OUT21/7466

**Martins Creek Quarry Project (SSD-6612)  
Response to Submissions (RTS)**

# Detailed advice to DPIE Planning & Assessment regarding the Martins Creek Quarry Project (SSD-6612) RTS

Proposed Water Management  
System Plan Year 25

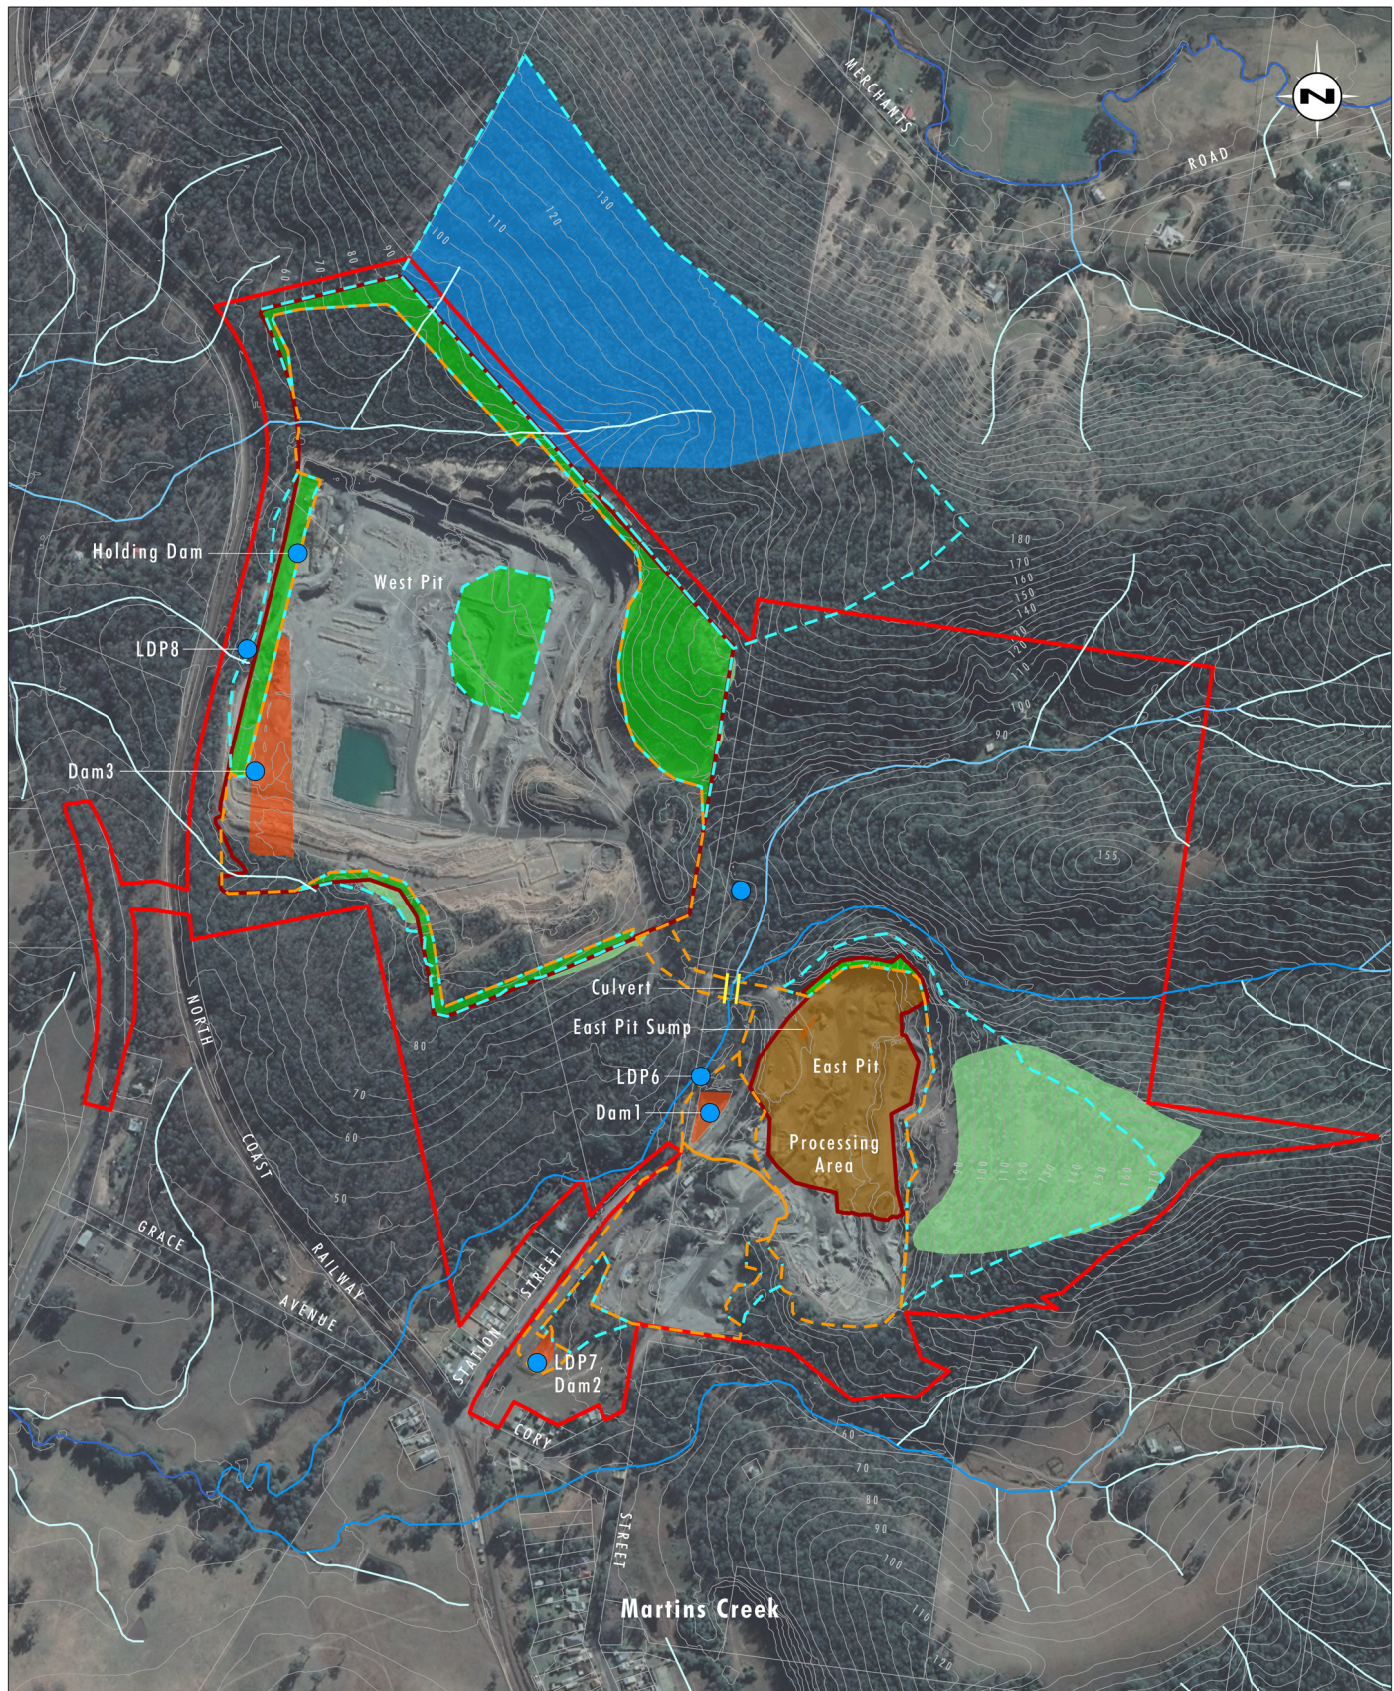
- Review the surface water management system to separate runoff from undisturbed and disturbed catchments. This needs to be maximised to achieve best practice and to minimise the requirement to hold water licences. The use of clean water dams that are sized within the Maximum Harvestable Rights Dam Capacity and clean water diversions where appropriate is recommended.

- Review the surface water management system to ensure dams on minor streams are either: 1) consistent with the Maximum Harvestable Rights Dam Capacity of the property, 2) satisfy the exclusion in Sch 1(3) of the WM Reg 2018 which requires the dam to be used solely for the purpose of the exclusion, or 3) considered for water licensing.
